WEST SUSSEX COUNTY COUNCIL CONSULTATION

TO:	Arun District Council FAO: Maria Tomalova
FROM:	WSCC - Highways Authority
DATE:	17 June 2021
LOCATION:	Land Rear of Sundown, Littleheath Road, Aldingbourne, BN18 0SR
SUBJECT:	AL/66/21/PL 1 No. 4 bedroom detached dwelling with a detached 3 bay garage (2 open bays and 1 enclosed), associated foul field drain, storm soakaway, new front boundary treatment, roof mounted PV & Ground Source Heat pump System (resubmission following AL/32/19/PL). This site is in CIL Zone 3 and is CIL Liable as new dwelling.
DATE OF SITE VISIT:	N/A
RECOMMENDATION:	Advice
S106 CONTRIBUTION TOTAL:	N/A

PROJECT AND DRAWING NO.
17-1197 — PL 401

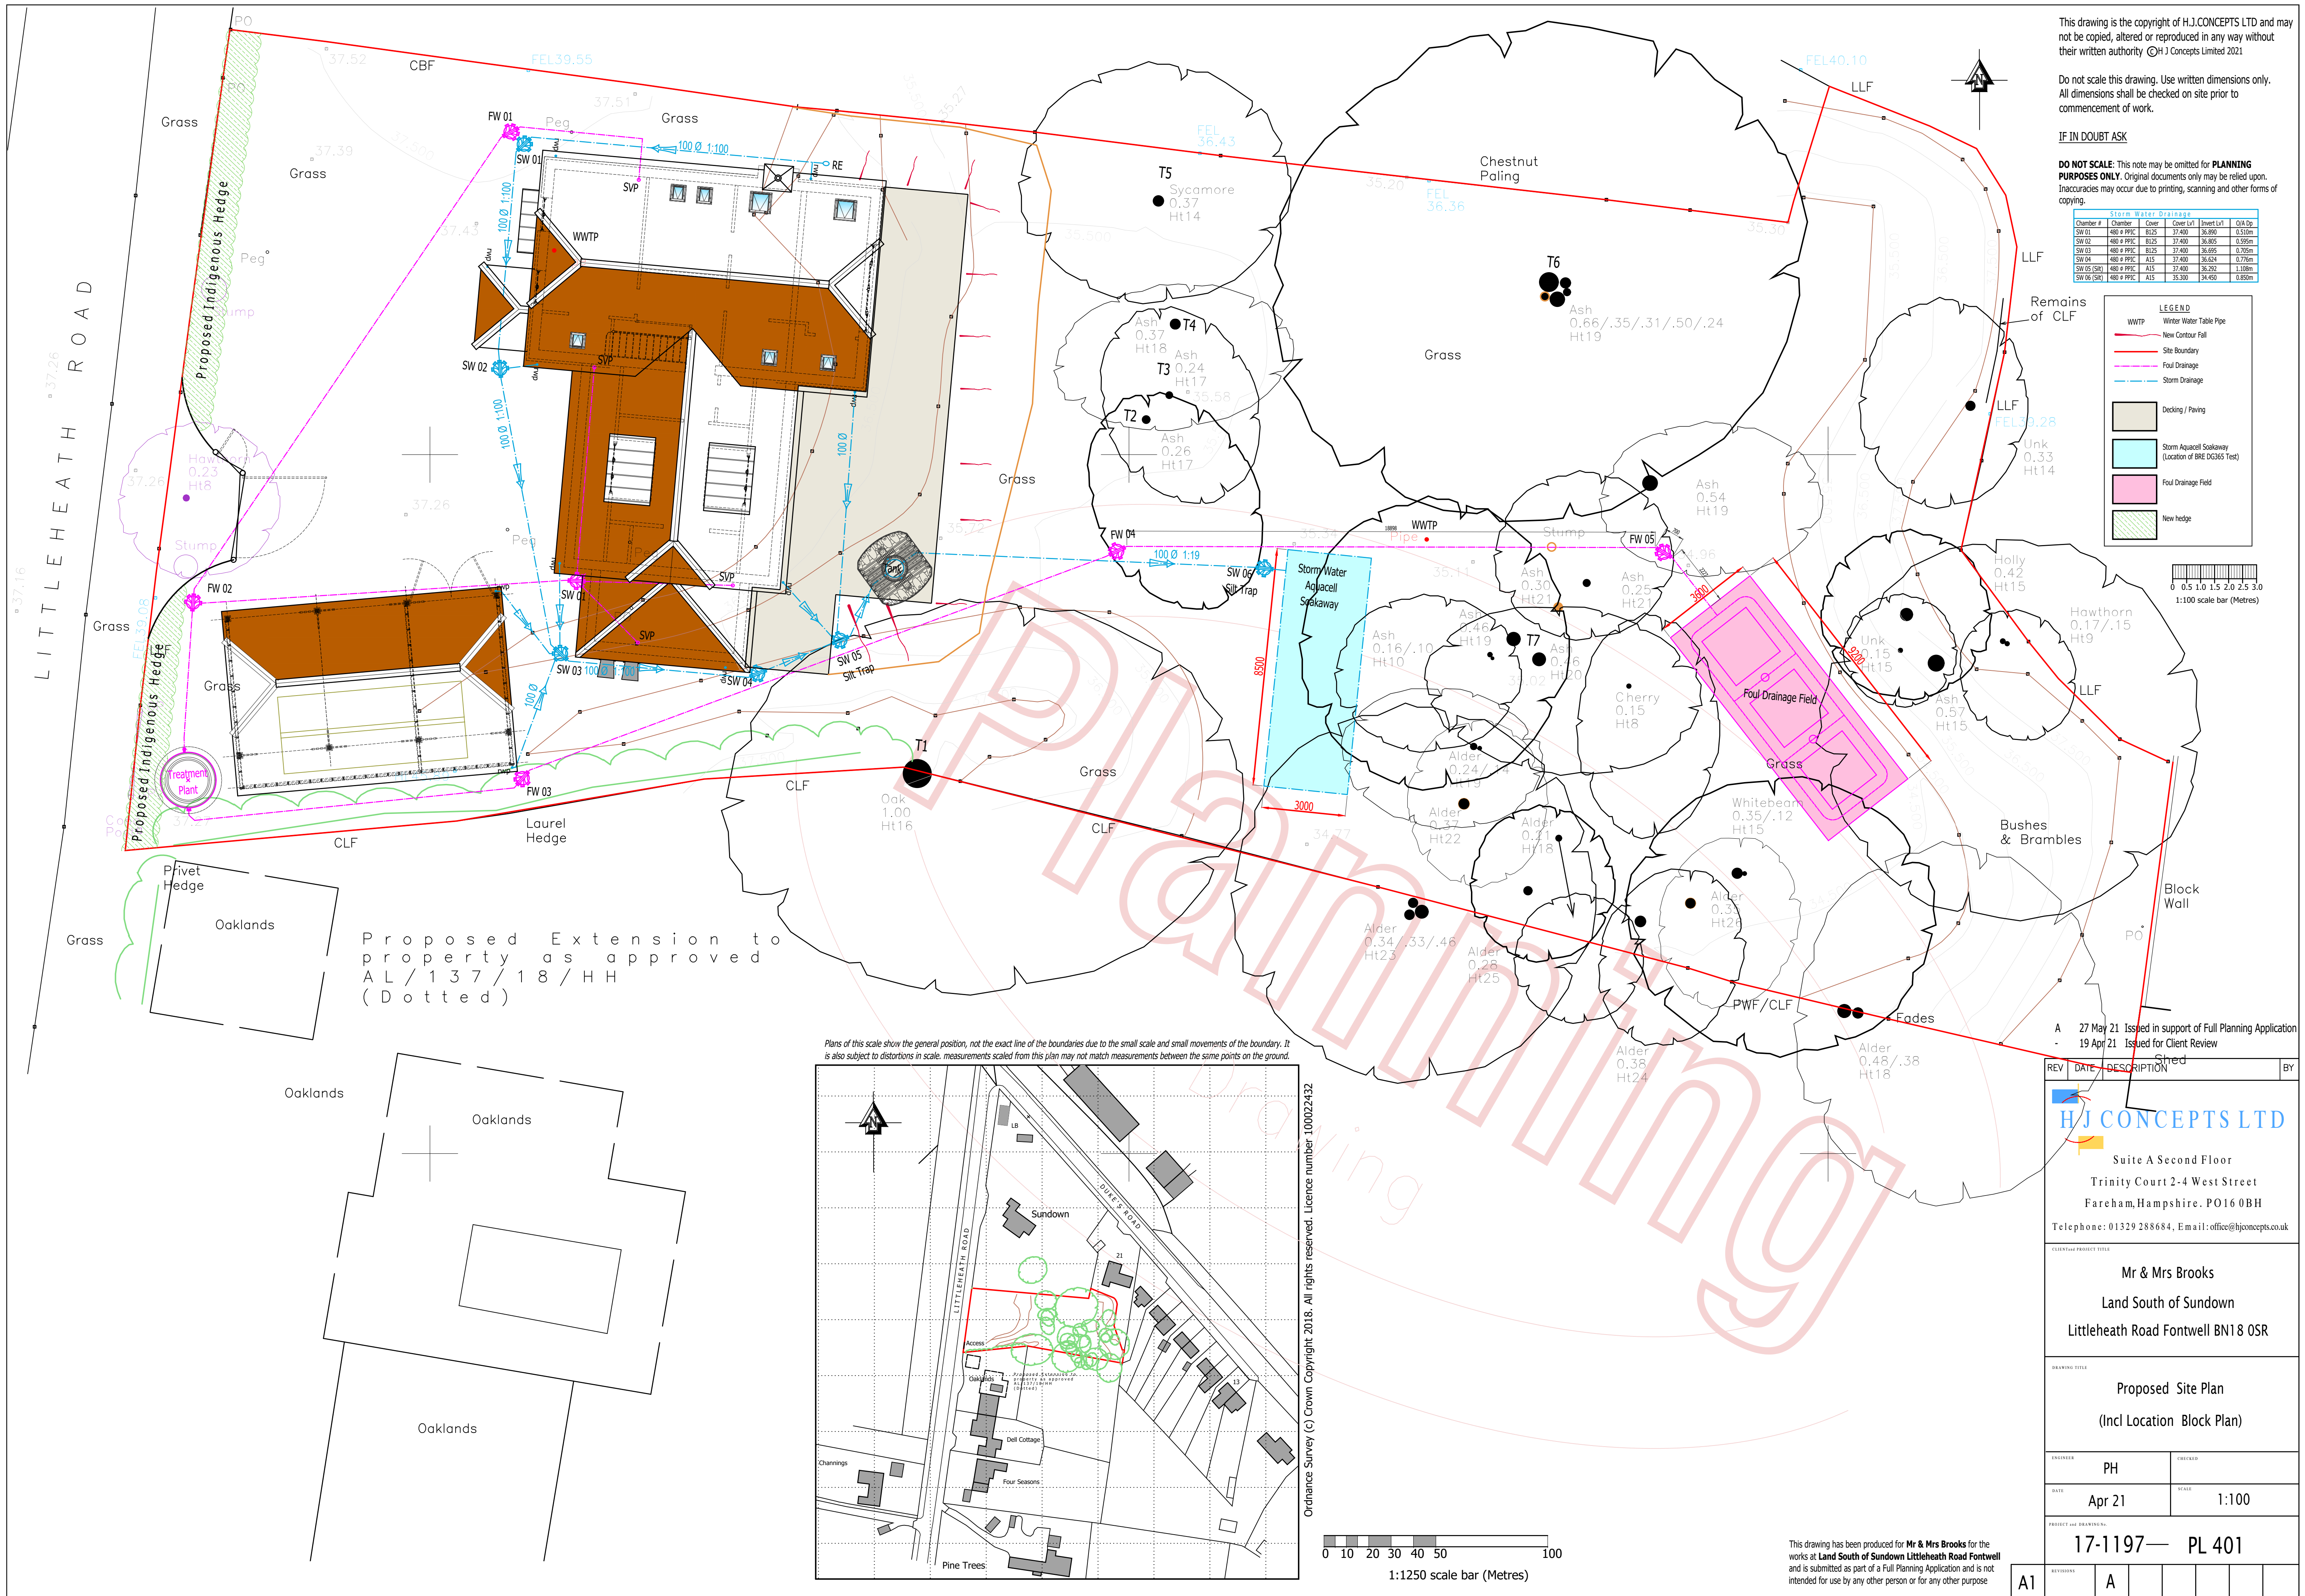
The applicant proposes to relocate an existing vehicular access 10m north, to form a new access. The proposed access works will be subject to a vehicle crossover (VCO) licence obtained through the local area office and constructed to a specification agreed with the local area engineer.

The proposed access gates will open inwards of the site and are set back 5m from the back edge of the carriageway, allowing cars to pull in off the carriageway and wait whilst the gates are in operation.

For vehicular parking provision, the applicant proposes a three-car garage, with space to park in front of these garages. Under Arun Parking Standards, a dwelling of this size in this location would require at least three parking spaces. Therefore, the LHA considers the proposed parking provision

to be acceptable. From inspection of the plans, the garages are suitably sized and there is space for on-site turning to be achievable.

No part of the development shall be first occupied until such time as the vehicular access serving the development has been constructed in accordance with the details shown on the drawing titled "Proposed Site Plan" and numbered "17-1197 – PL401".
